**PLANNING APPLICATION CONSULTATION RESPONSE**

<b>Application Number:</b>	3/2023/0465
<b>Proposal:</b>	Erection of one new dairy cattle building with underground slurry tanks, associated hard standing and solar panels to south facing roofscape, removal of redundant metal ring slurry store and erection of two concrete slurry tanks with canopies.
<b>Location:</b>	Black Moss Farm Elmridge Lane Chipping PR3 2NY

The Lead Local Flood Authority **maintains its objection** to the above application on the basis of:

Drawing
Proposed Surface Water
Drainage Layout

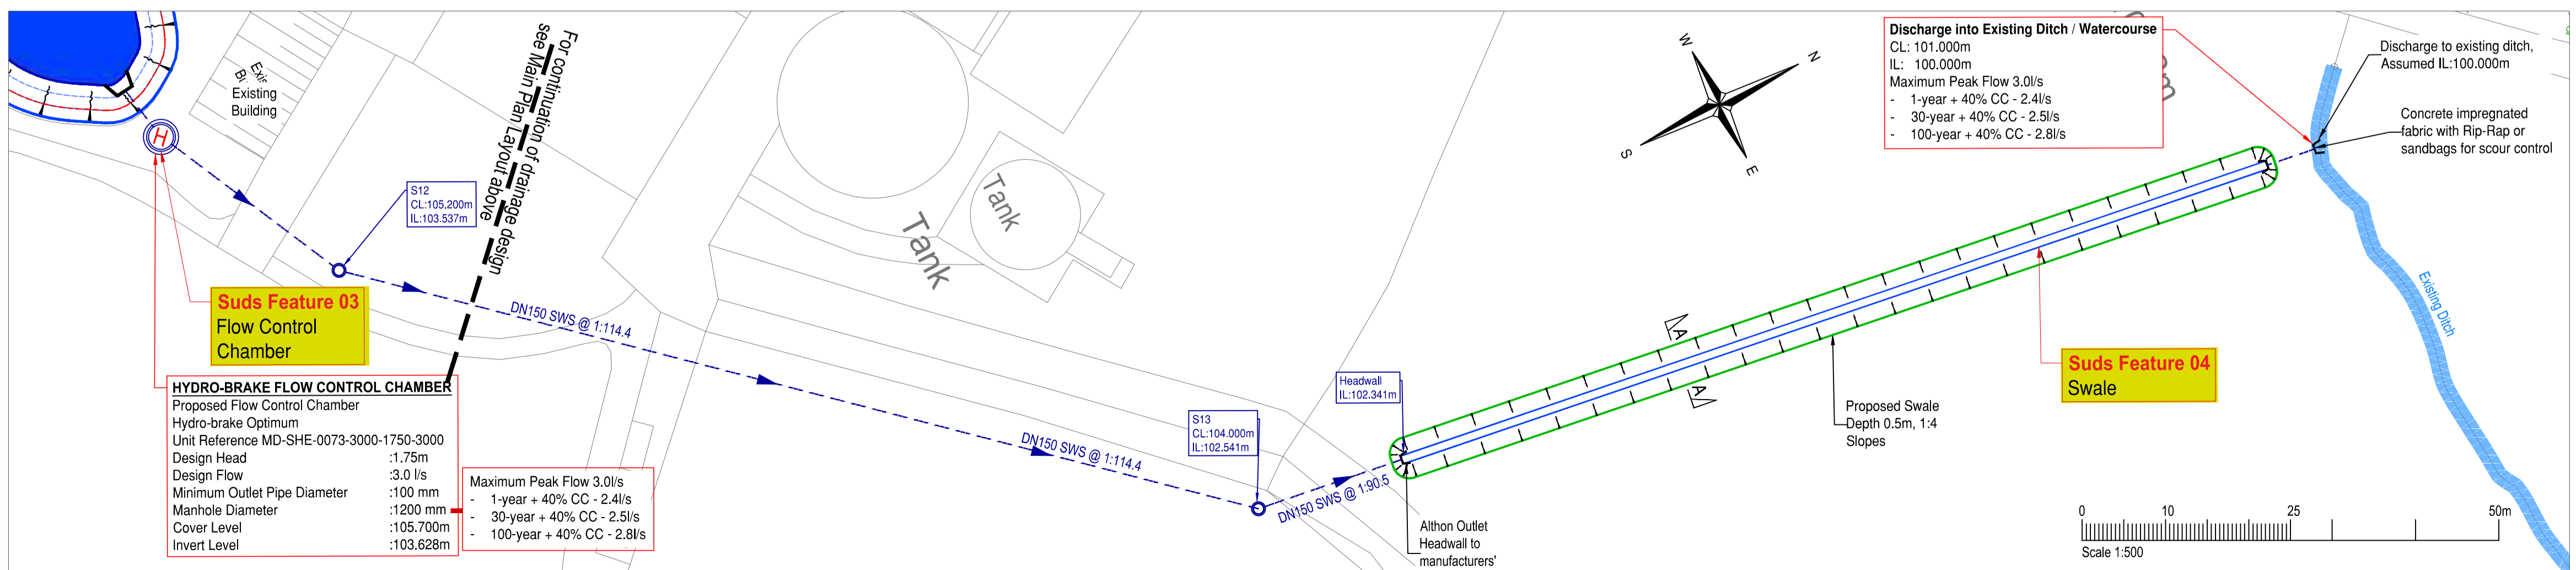
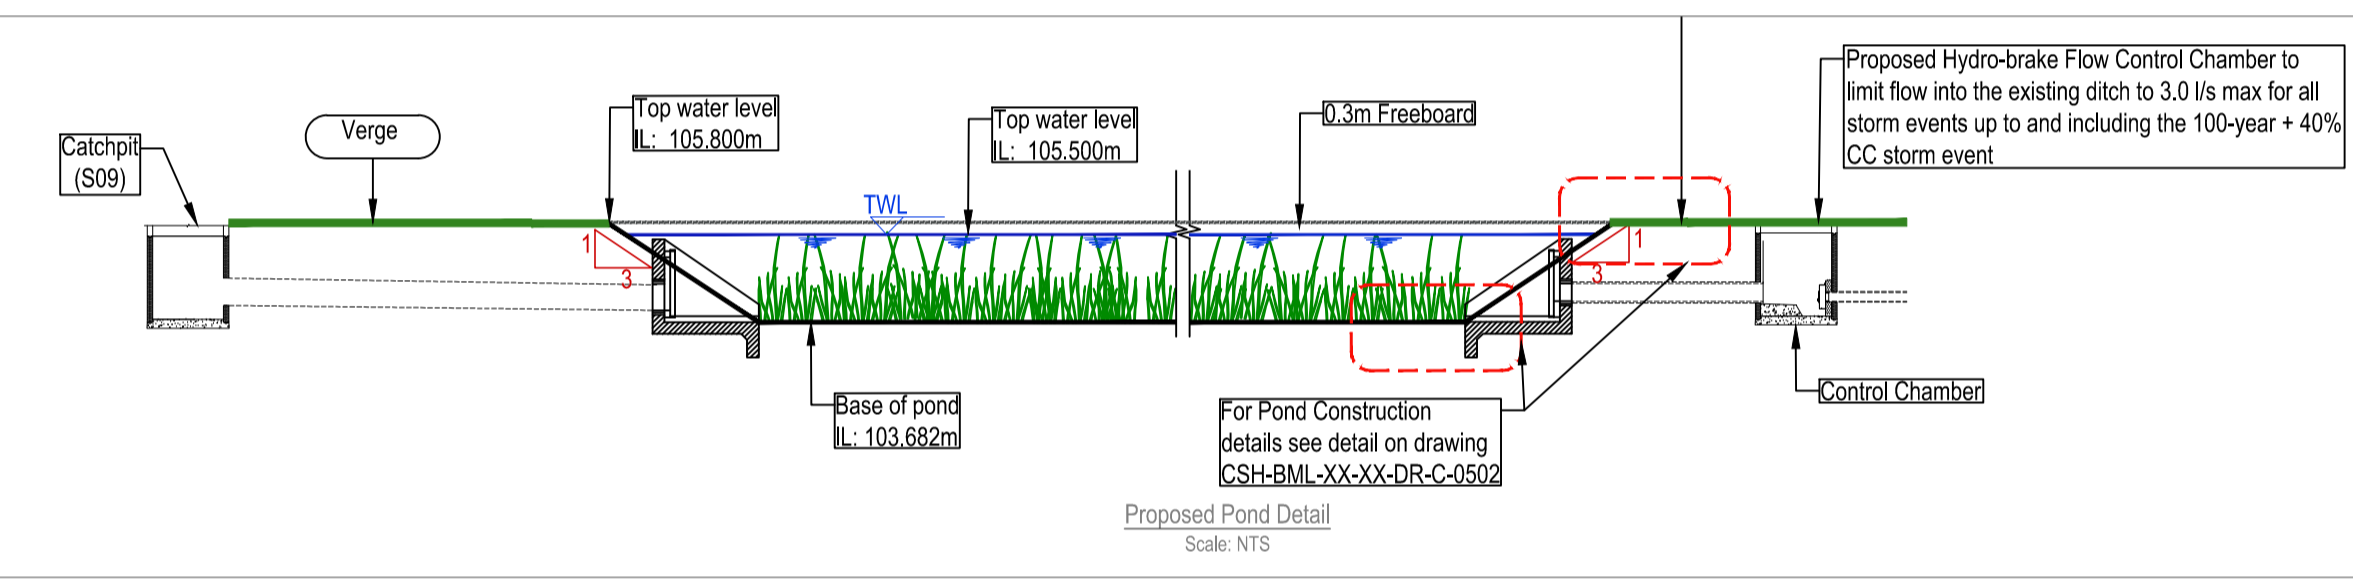
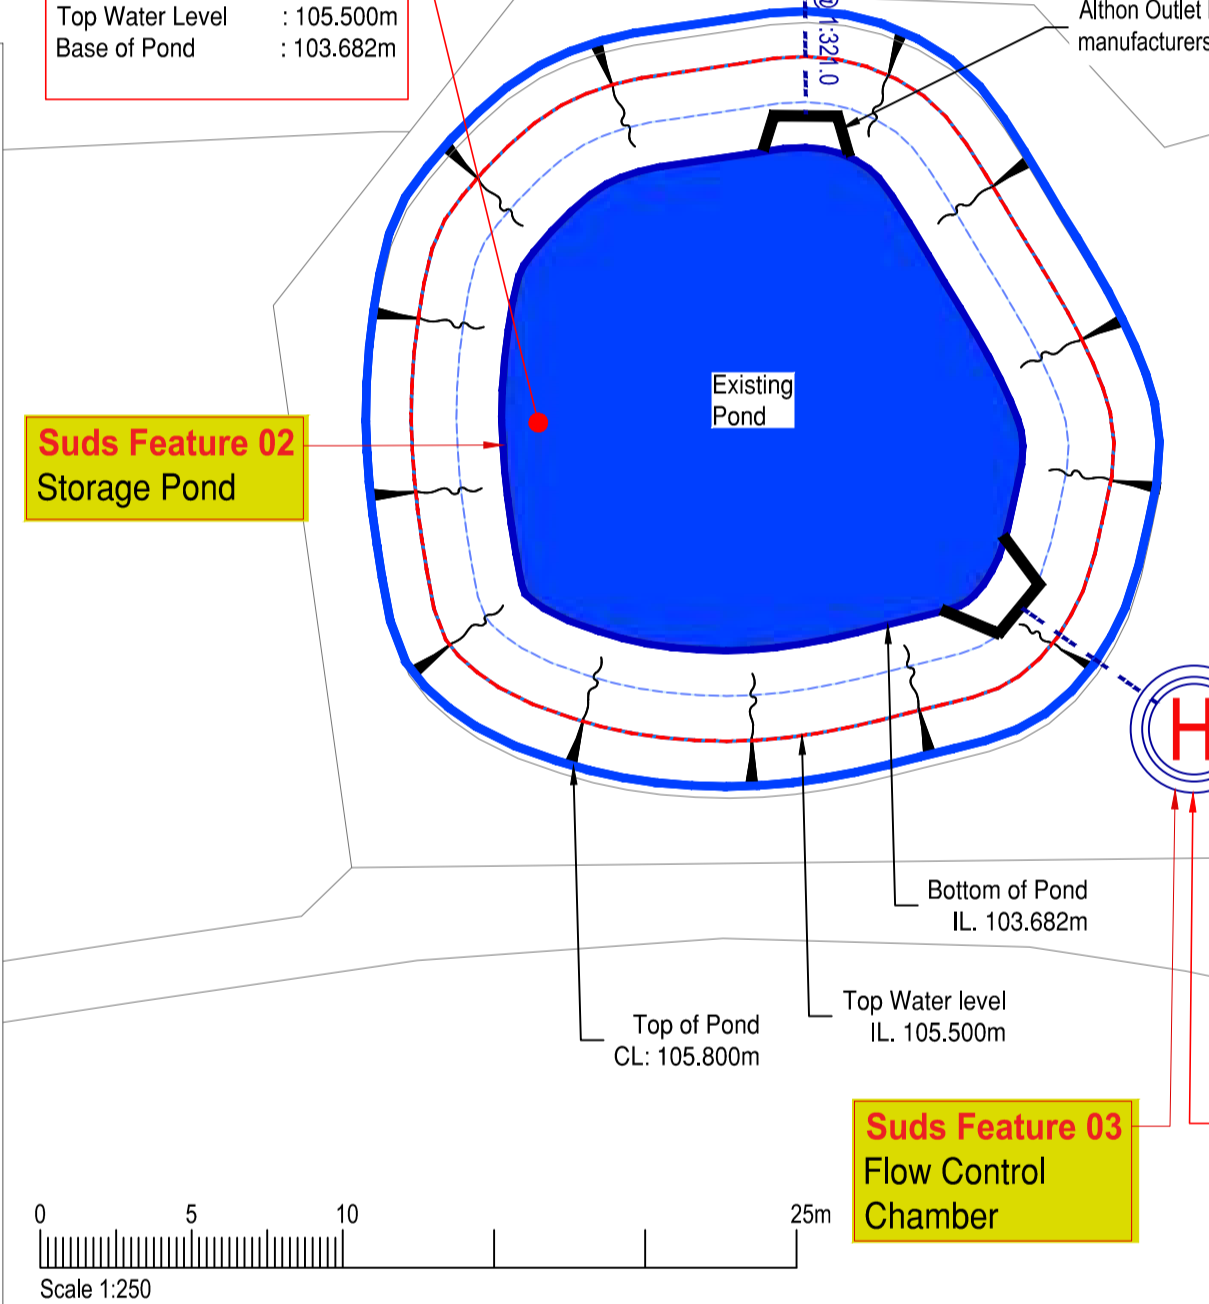
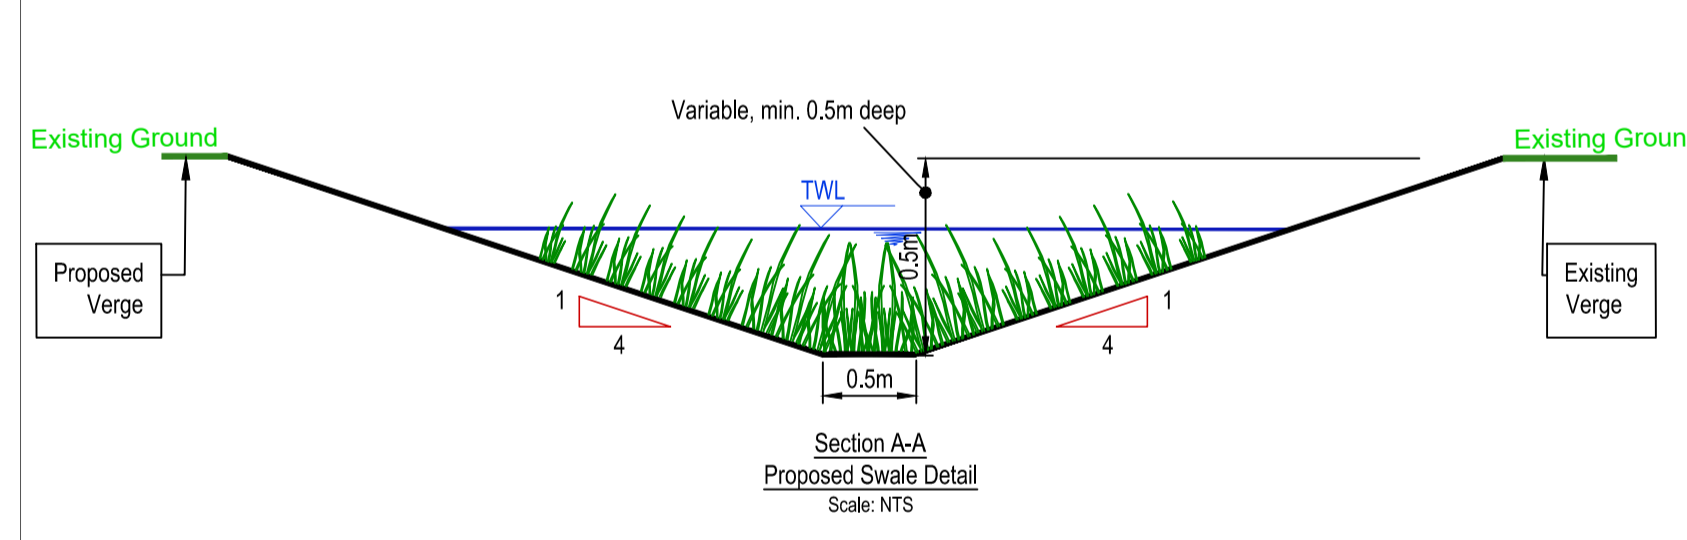
The objection points relating to peak runoff rate and volume control are maintained due to the applicant having failed to provide updated information in regard to the slurry tanks on the east of the development site. These proposed slurry tanks are to be constructed on greenfield land and will be therefore altering the existing permeable area to impermeable post development, requiring the applicant to apply the same greenfield drainage principles that they have applied to the cattle building on the west of the development site.

The applicant has proposed to discharge surface water from the development via an existing pond, given that the pond is existing, the applicant is expected to provide evidence as to the suitability of the pond for storing surface water post development, given the conversion of greenfield to impermeable area. As a result of the pond being existing, the applicant should ensure to provide estimations of the required volume needed for the proposed development, in comparison to the amount of volume the pond currently has capacity for, in order to ensure that the pond can accommodate the existing volume as well as the post development volume.
